Application # 0650015616R

COUNTY OF HARNETT LAND USE APPLICATION

**Re: Status of Improvement Permit Application #06-5-15616**

H0H Const.  
Lot 150 Woodshire  
06-500 15616

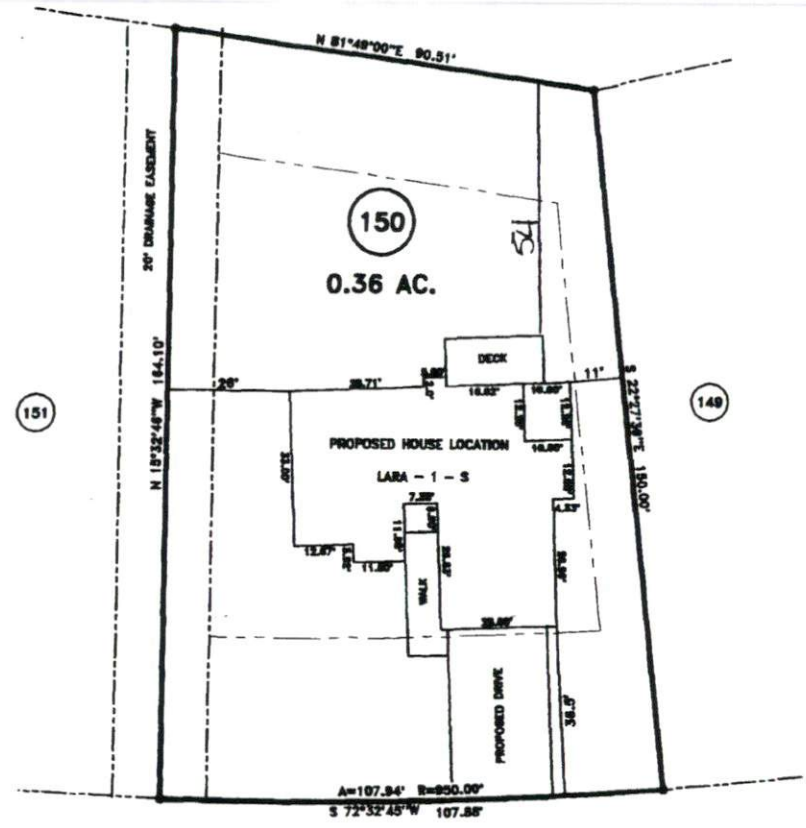
- 1. Property lines/corners not marked or labeled
- 2. House corners not marked or labeled
- 3. Directions not clear to property
- 4. Property needs brush or vegetation removed
- 5. Backhoe pits required
- 6. Other – Move house as shown on attached sheet and resubmit to Central Permitting.

- 1. Property lines/corners not marked or labeled
- 2. House corners not marked or labeled
- 3. Directions not clear to property
- 4. Property needs brush or vegetation removed
- 5. Backhoe pits required
- 6. Other – Due to the location of storm ponds, and required setbacks, house size, and the number of bedrooms, a proposed septic layout is required from your consultant. Submit as a revision to Central Permitting.
